From:
To:
Subject: Re: notice of Response to Submissions Report for the Australian Technology Park – Precinct Marker Signage Strategy (SSD-7317-Mod-19).
Date: Tuesday, 6 October 2020 2:24:40 PM

Lighting and Illumination

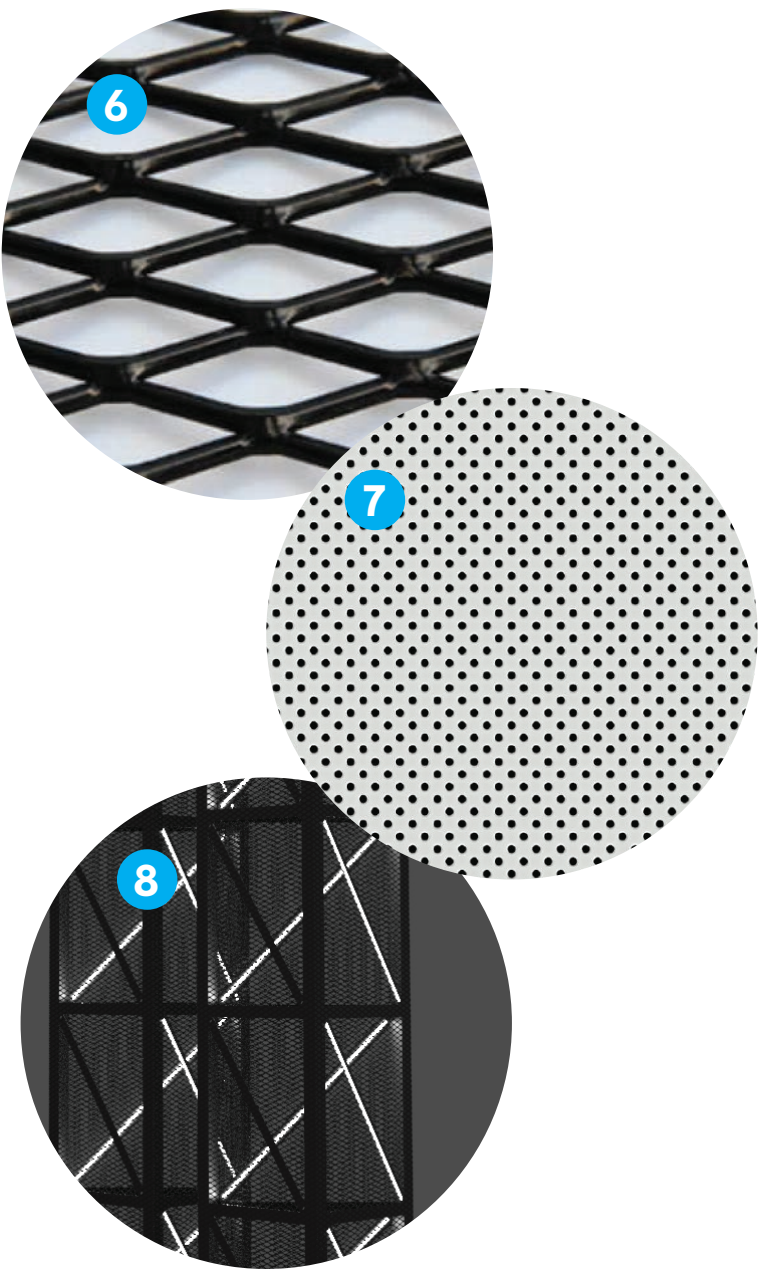
We do note, however, that the proposal for the lights operations hours are in variance to what was discussed and agreed with Mirvac when we met.

Given half of the residents have their only bedroom at the front and inbound traffic will be highly likely extremely limited late in the evening: can we please revert to the agreed outcome with Mirvac of dimmed signage from 10pm onwards?

This is a shared area and sleep / quality of sleep is very important.
